Contact name: Ellen Mannix
Number: 8275 1031
Email: Ellen.Mannix@planning.nsw.gov.au
Our ref: SSD 7056 MOD 2

**Modification to Campbell's Stores, The Rocks (SSD 7056 MOD 2)
Response to Submissions Letter**

Figure 1: Proposed Bay 11 Plant Room

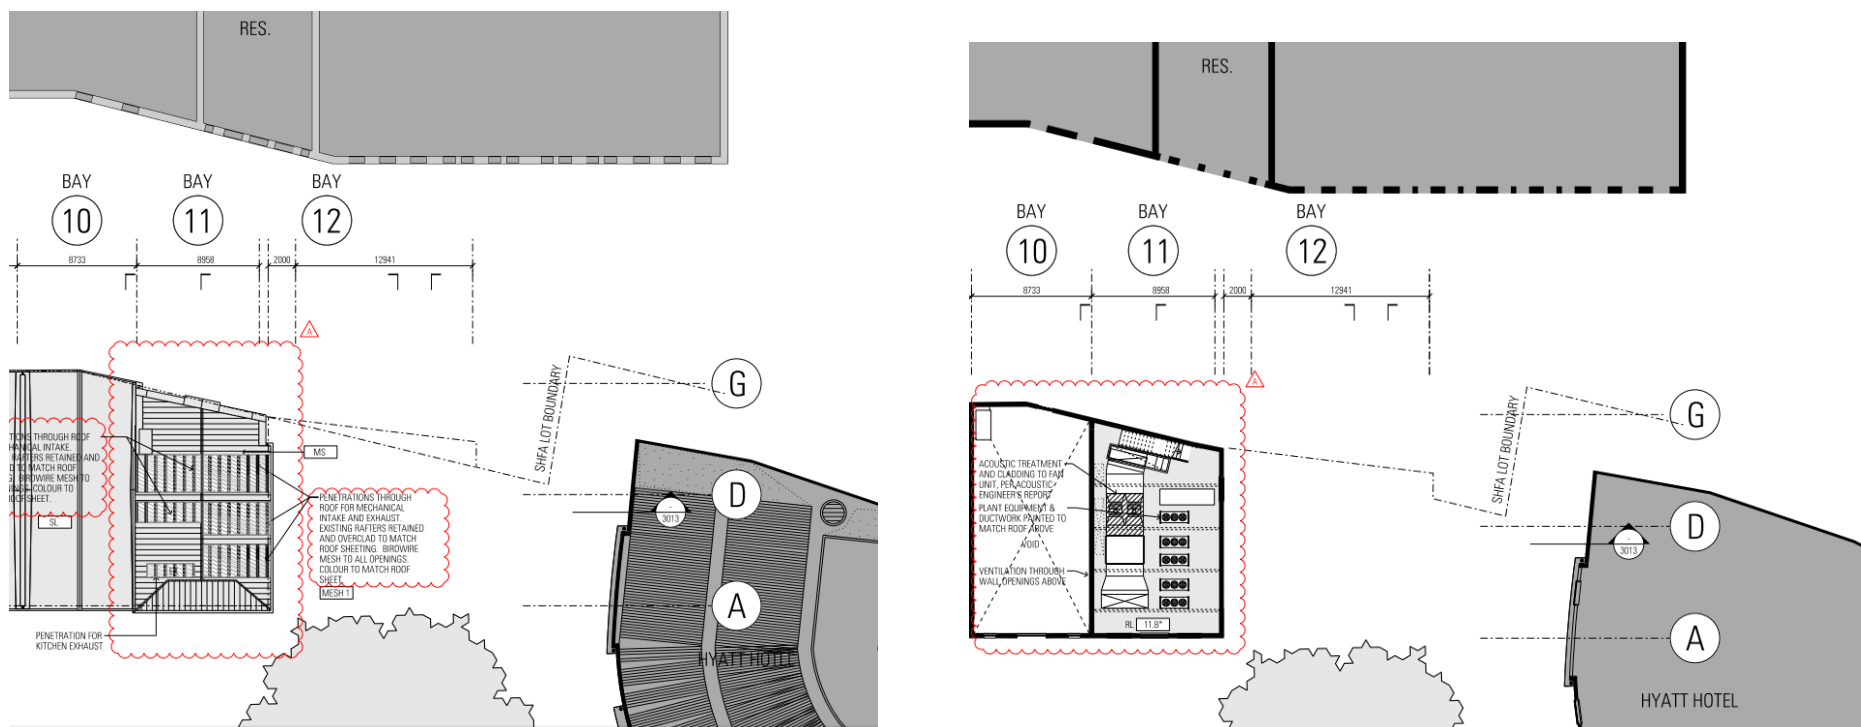
- Provide detailed design drawings for all mechanical ventilation equipment and odour control devices. The equipment is not to protrude above any part of the roof and adhere to the Construction Management Plan.
